PRELIMINARY WATER RESOURCES REPORT

**For
McLean
Minor Subdivision**

March 12, 2024

## Exhibit A

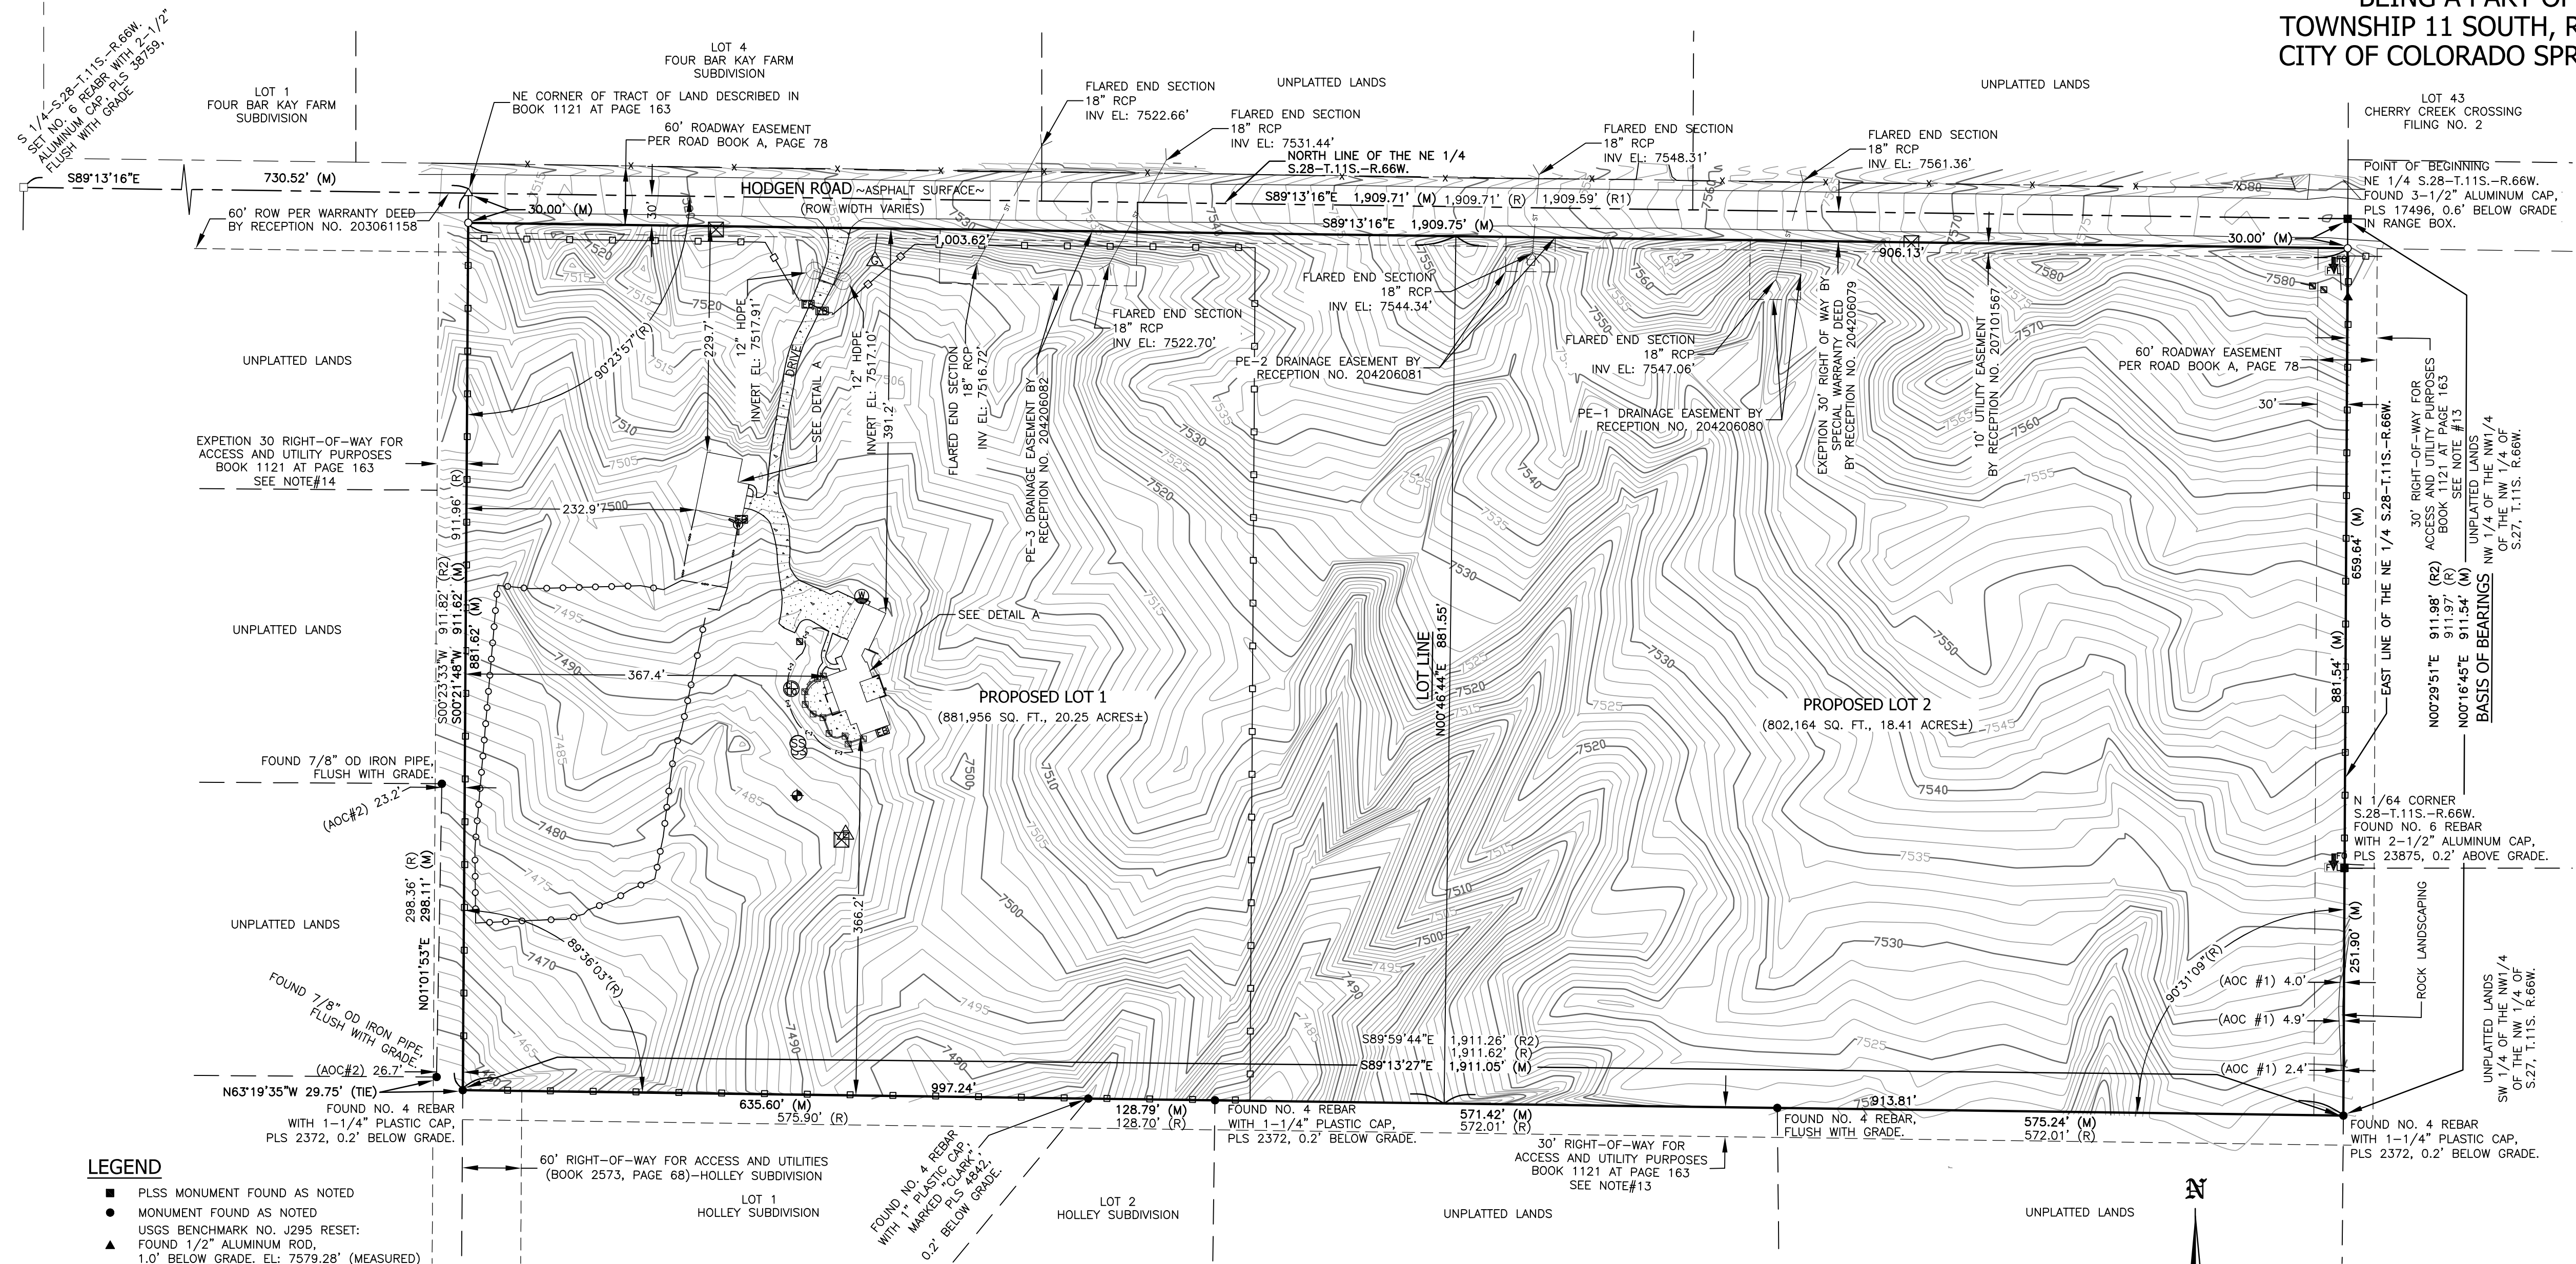
The water resources report states 1.75. Please clarify.

Please clarify one residence is permitted per lot.
